Application for a non-material amendment following a grant of planning permission.
Town and Country Planning Act 1990

SINGLE STOREY REAR EXTENSIONS

2026/90615

PATIO DOORS & WINDOW TO CHANGE TO
ONE SET OF BI FOLDS

scale	1 : 50
date	FEB '26
drawn by	
Dwg No	26 17
Rev

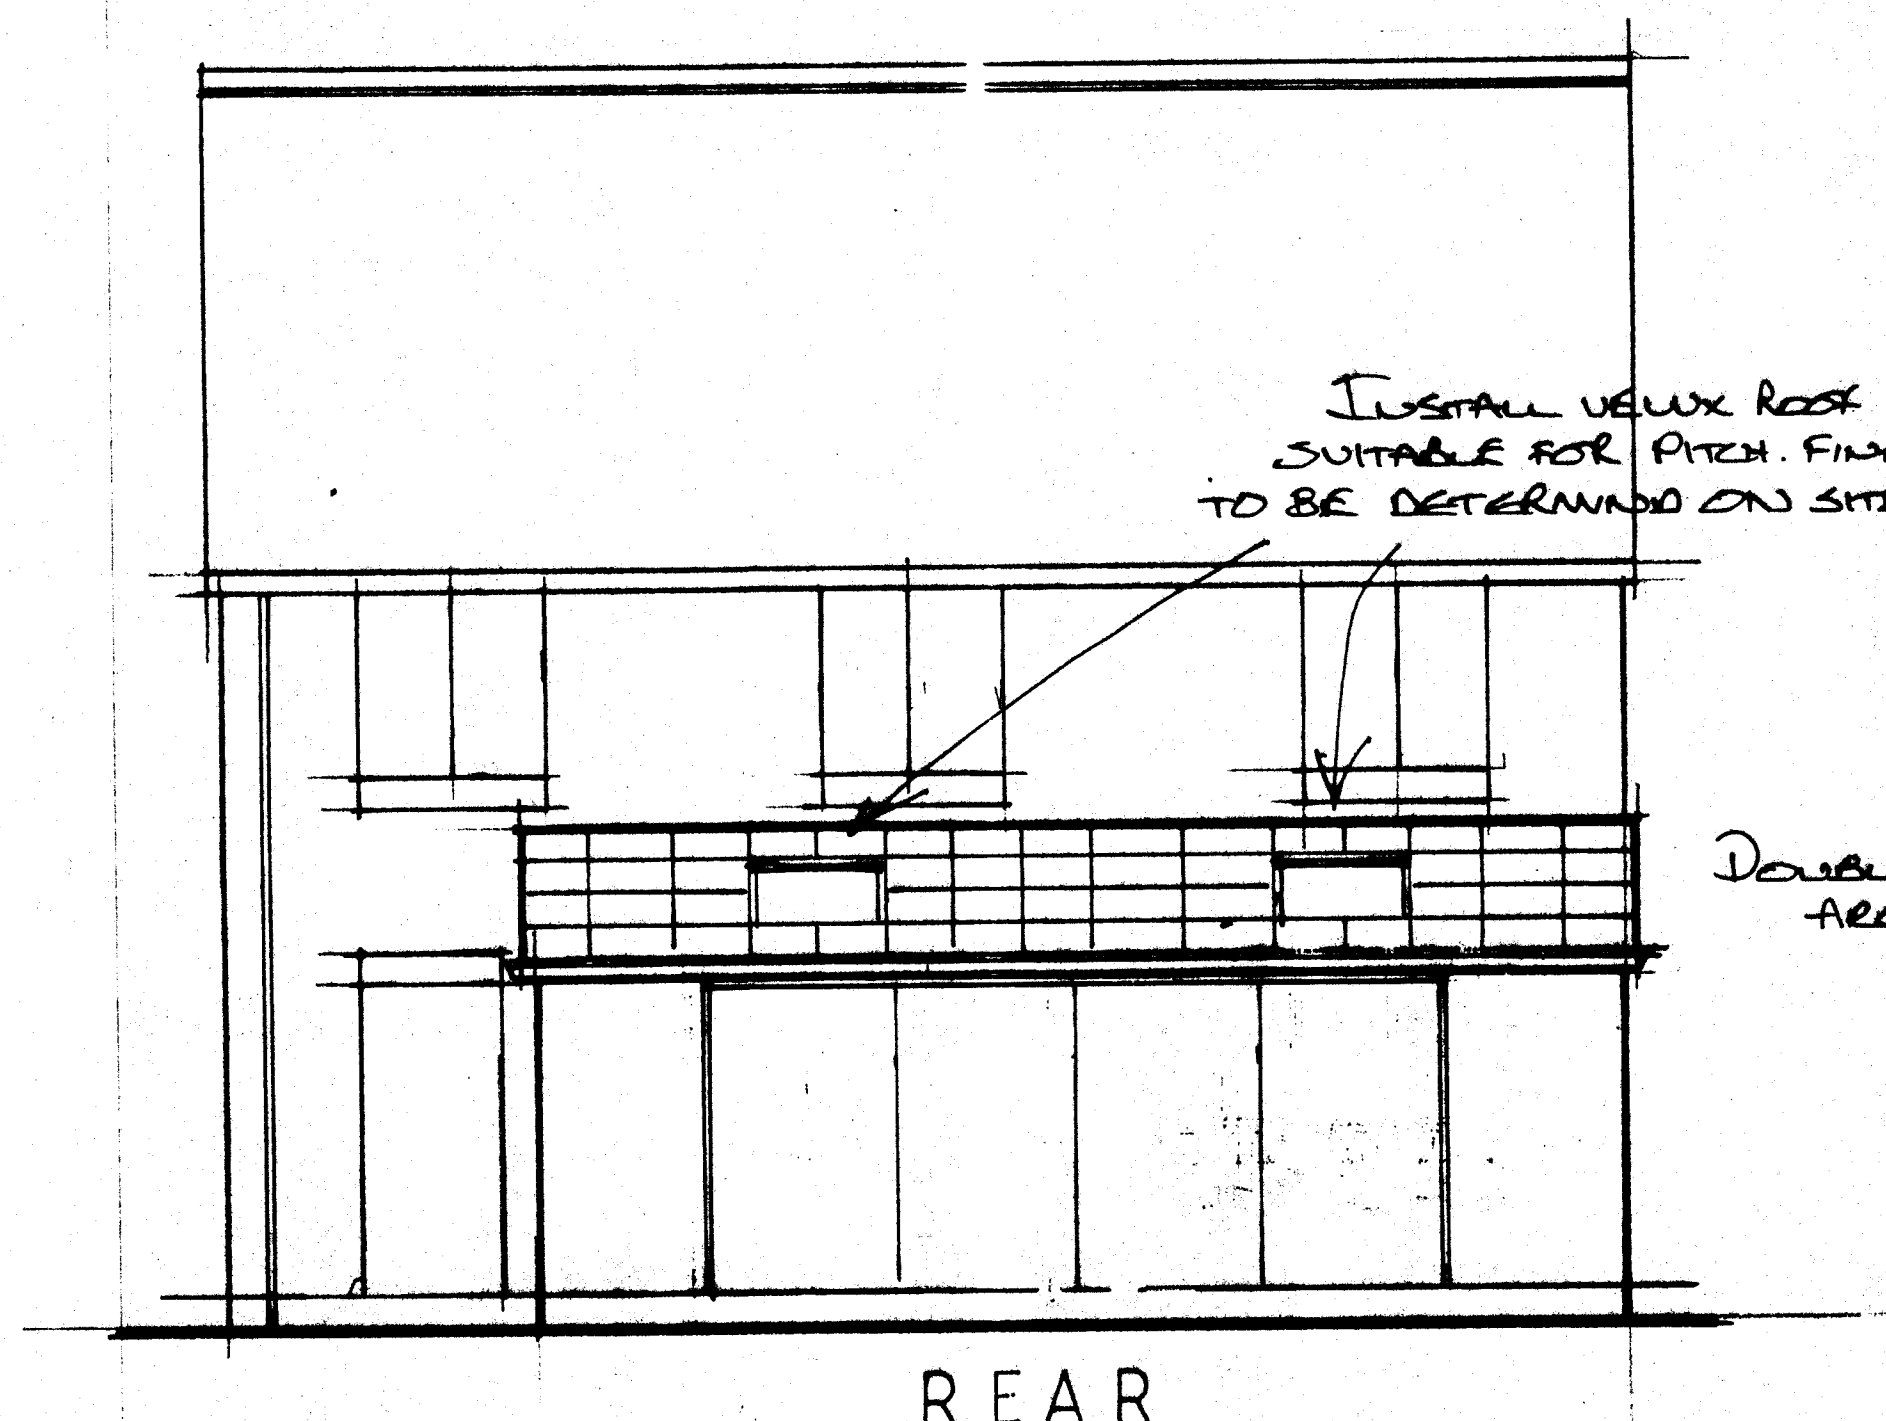
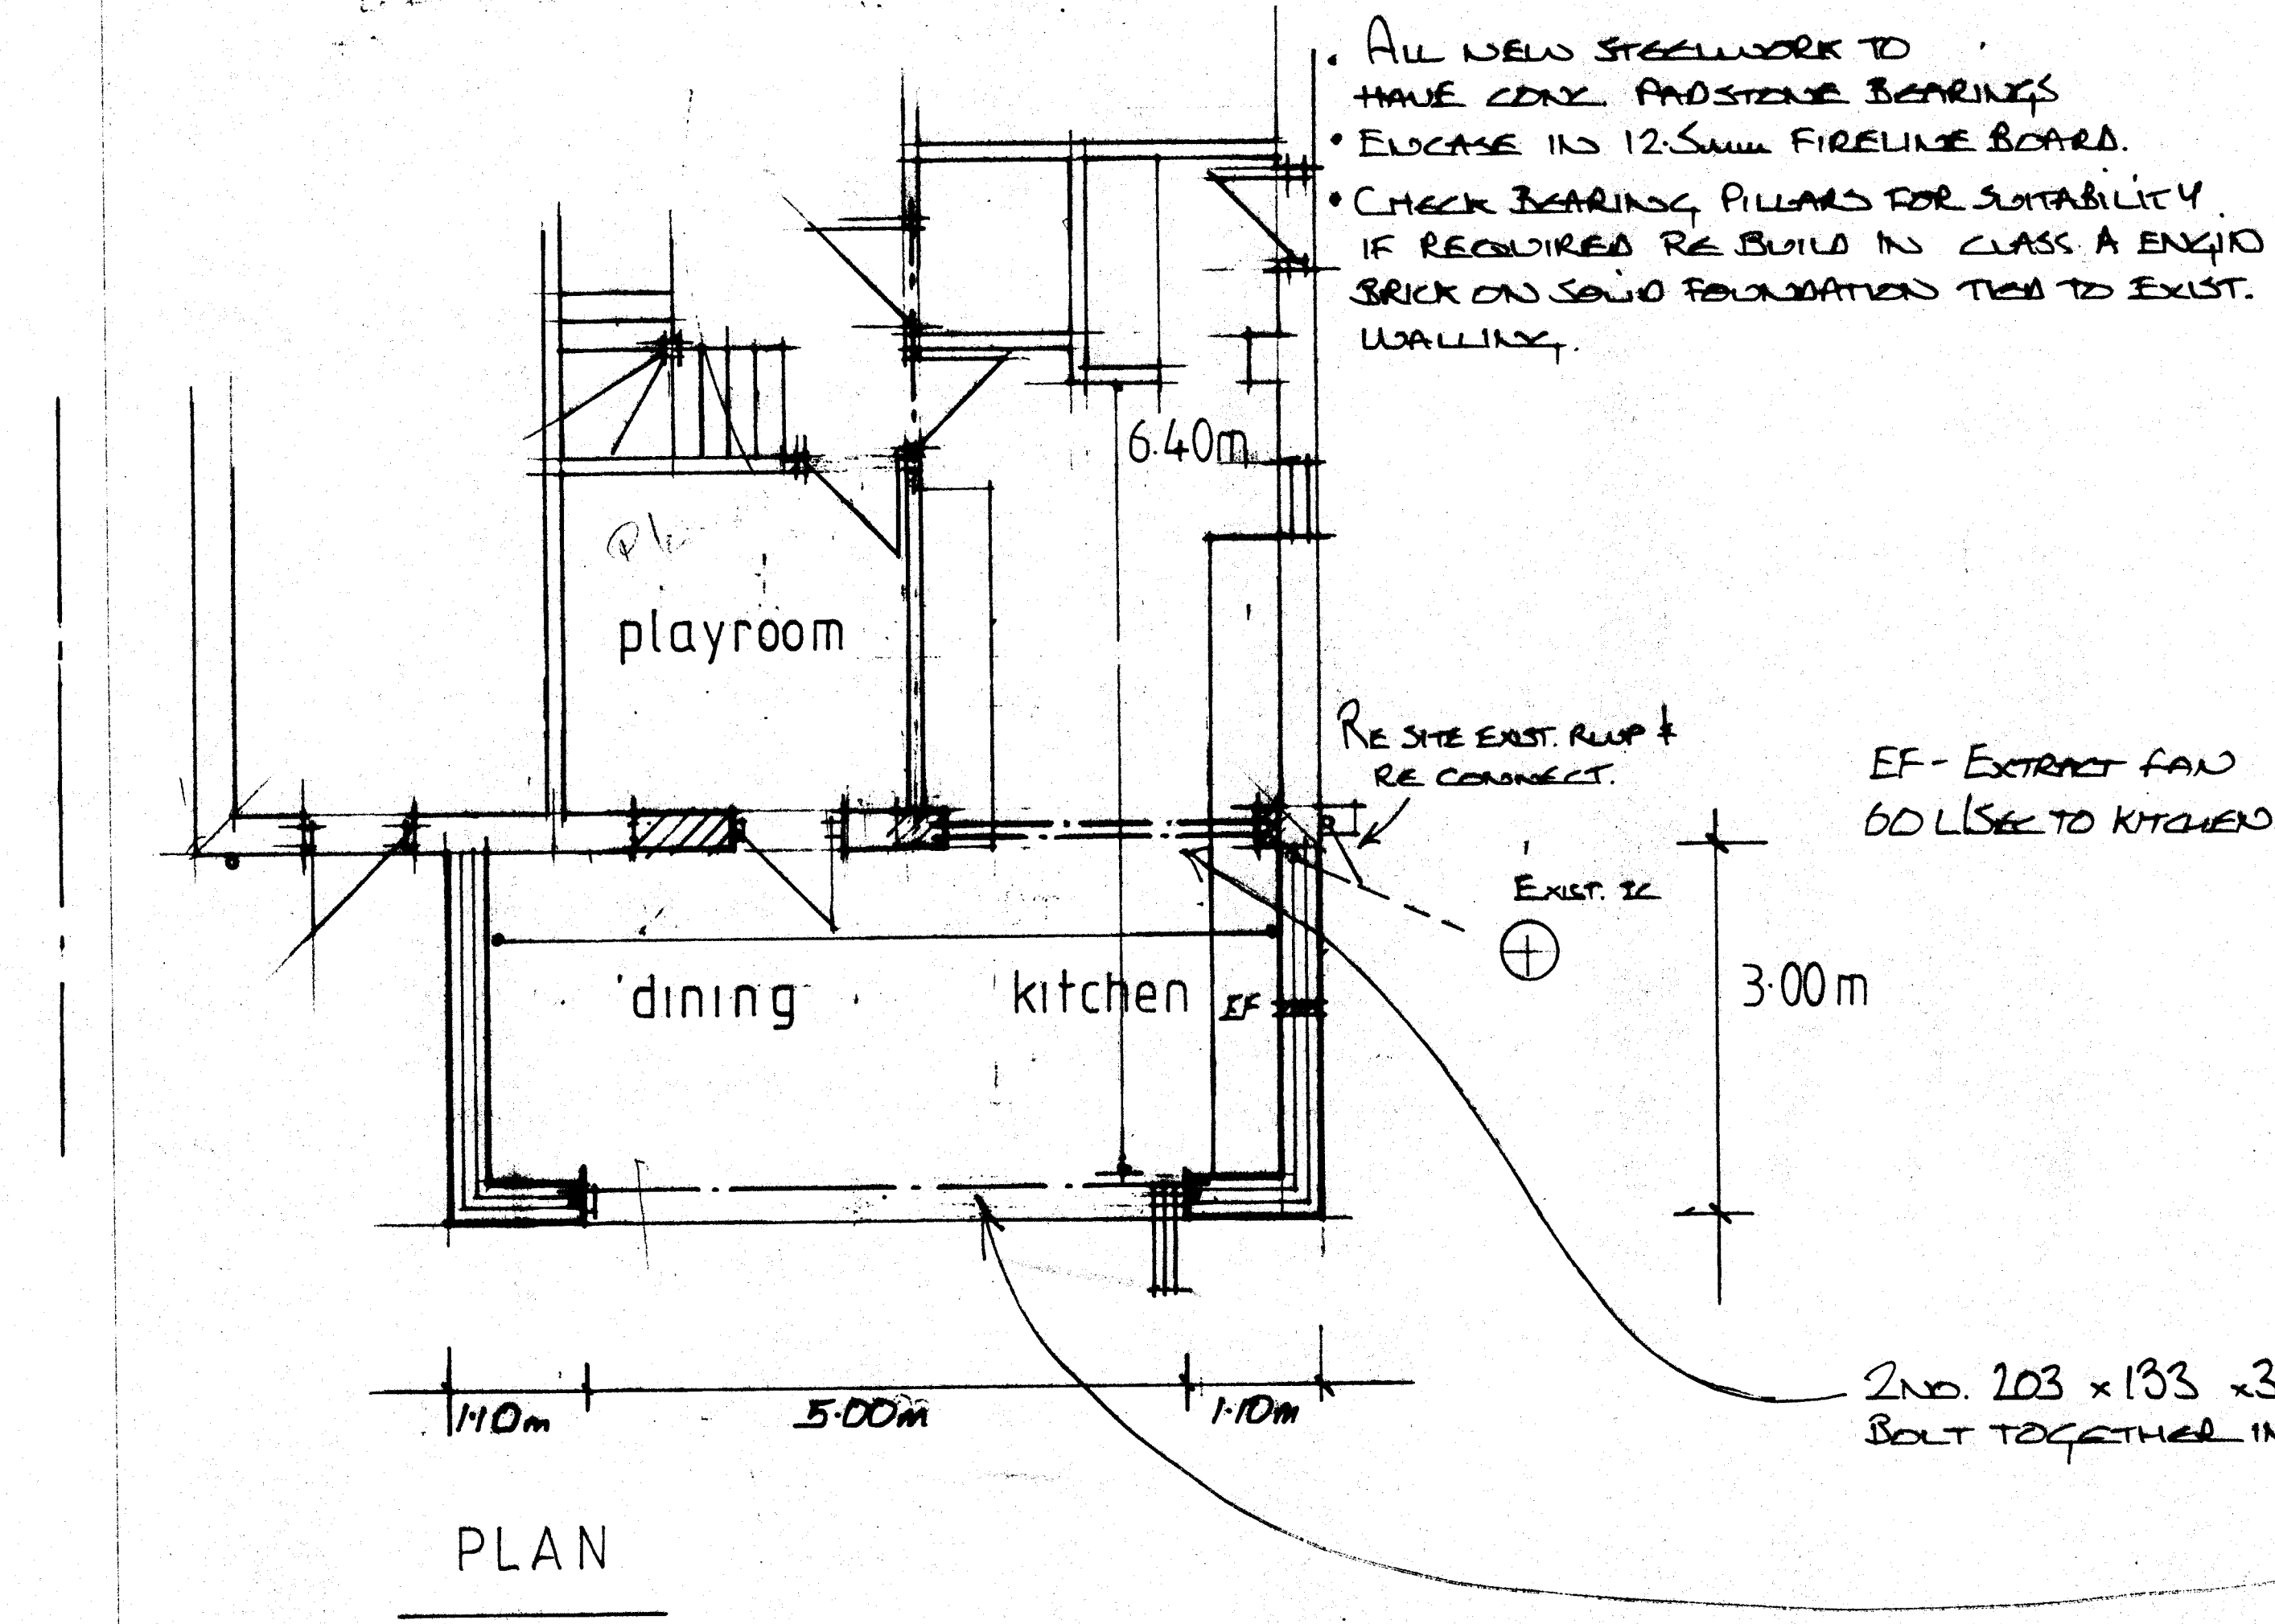
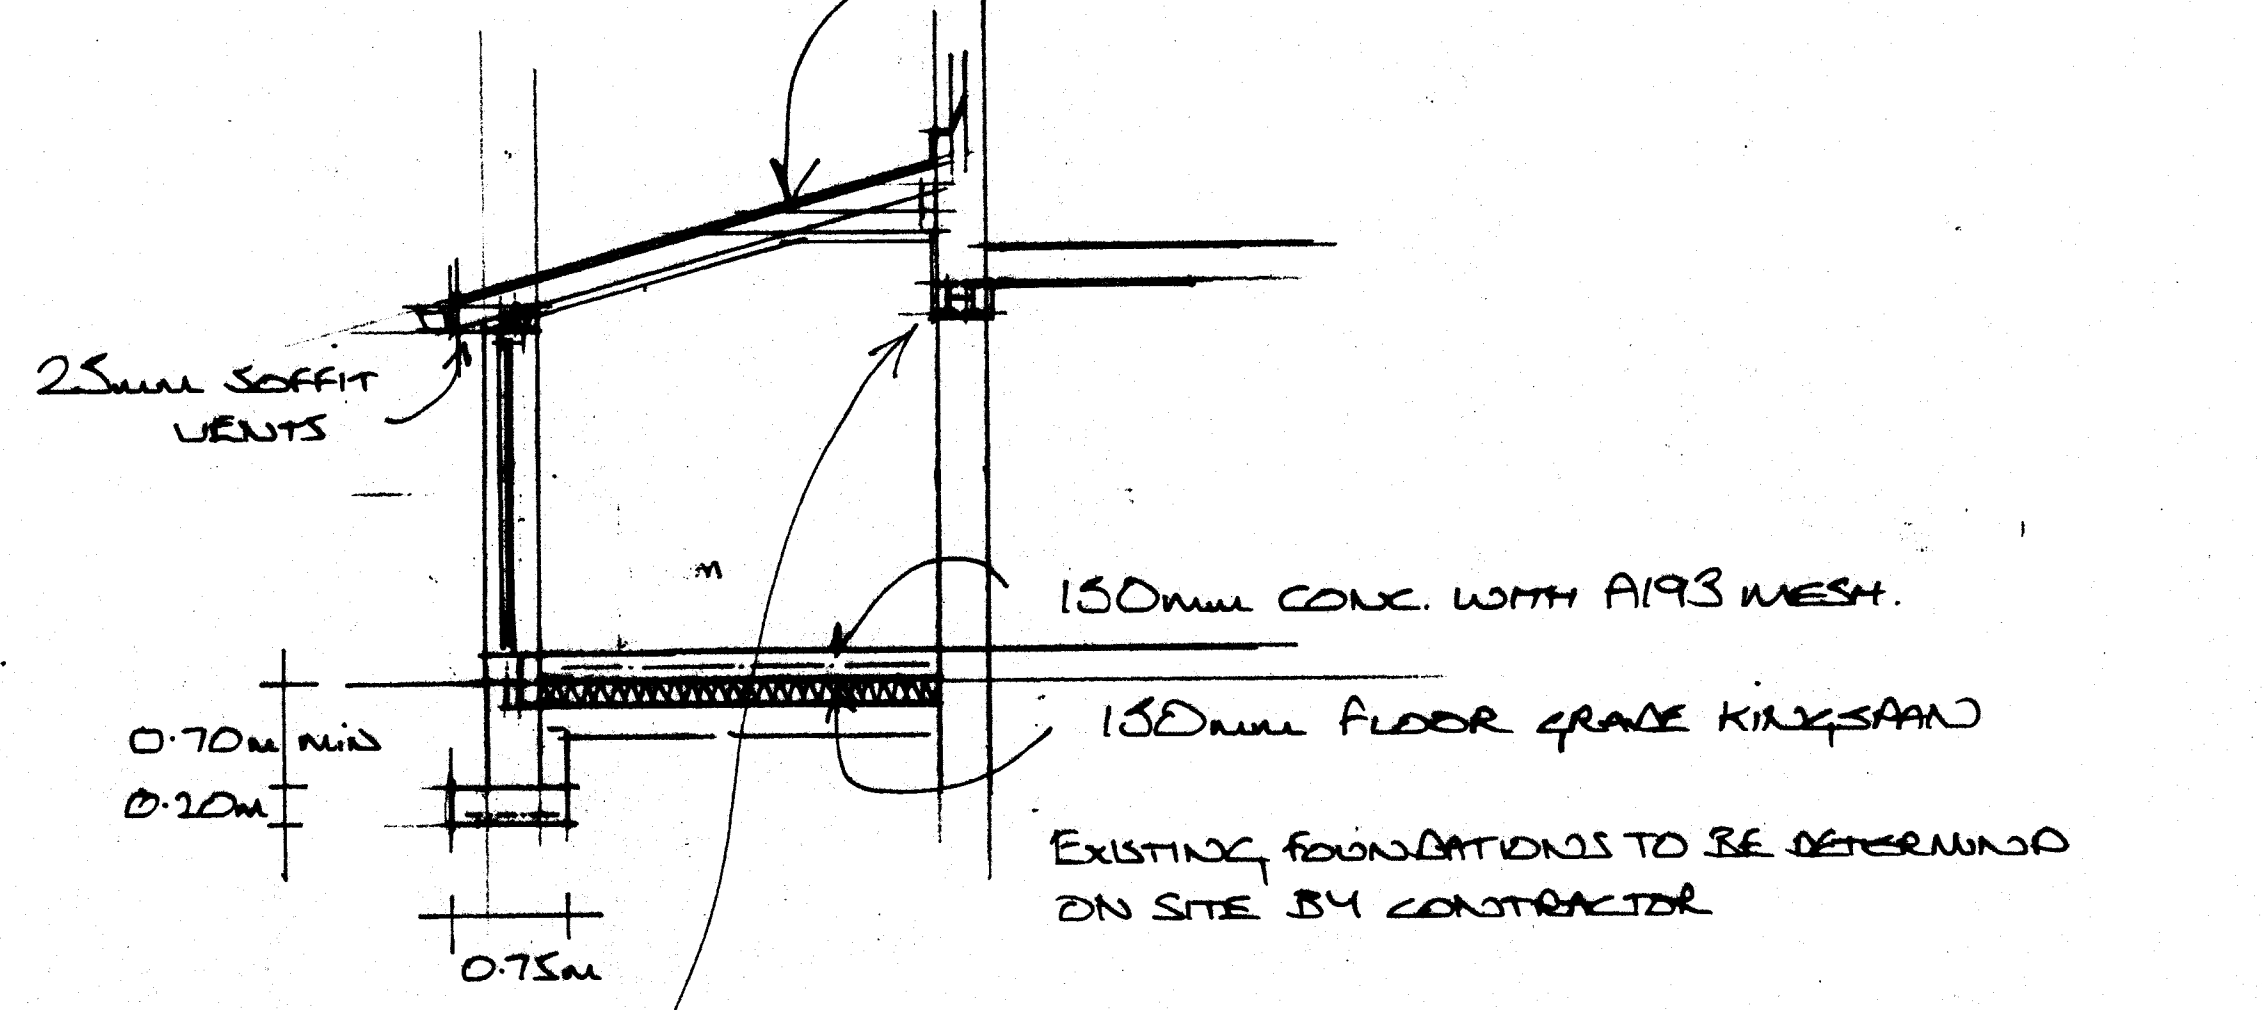
LIGHT & ACCESS TO GARDEN
